20 April 2017

SF2017/037839; WST17/00033

SSD6456: Narrabri Gas Project

Figure 8.3: Rural AUL(S) treatment with a short left-turn lane

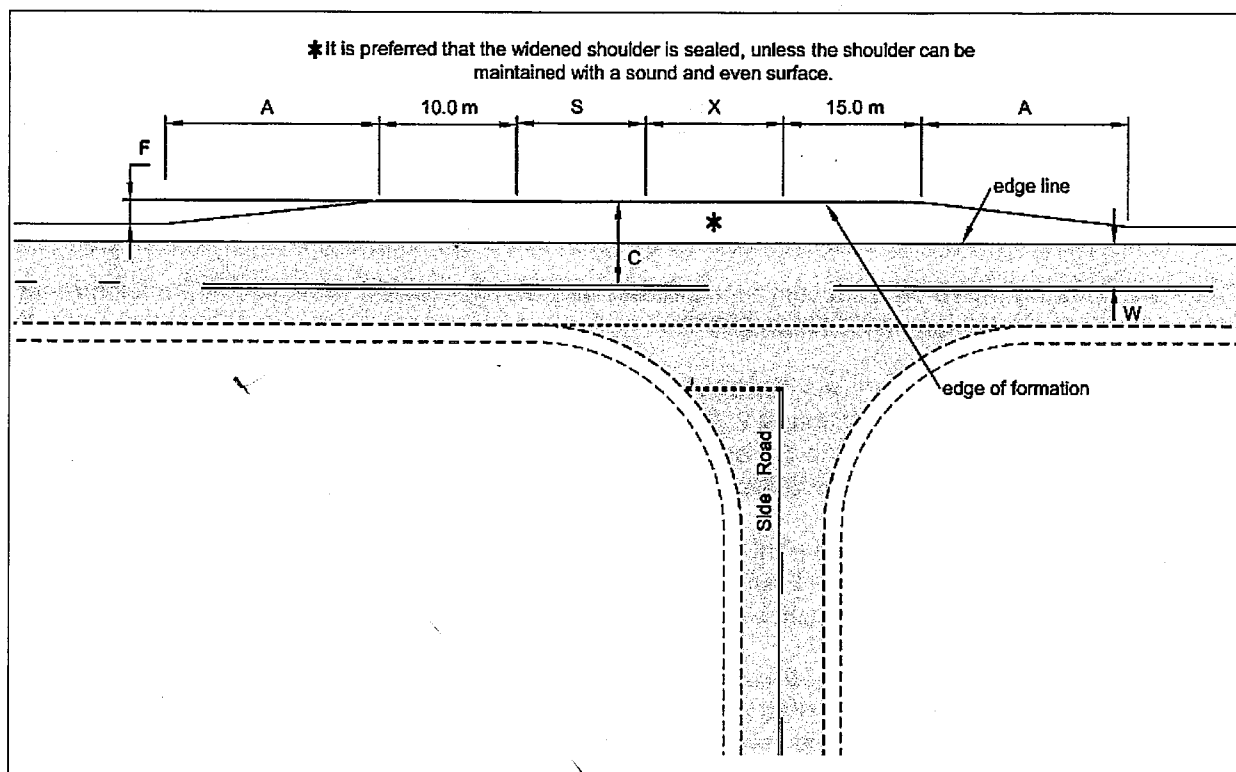
- The intersection of X-Line Road and the Newell Highway is to be upgraded to include sealed Auxiliary Left Short [AUL(S)] and Basic Right (BAR) turn treatments in accordance with Figures 8.3 & 7.5 Part 4A *Austroads Guide to Road Design* respectively (copies enclosed) and relevant Roads and Maritime supplements. The intersection works are to be designed and constructed to accommodate the largest vehicle accessing the intersection. Such designs are to be appropriate for the current speed zone of 110km/h.
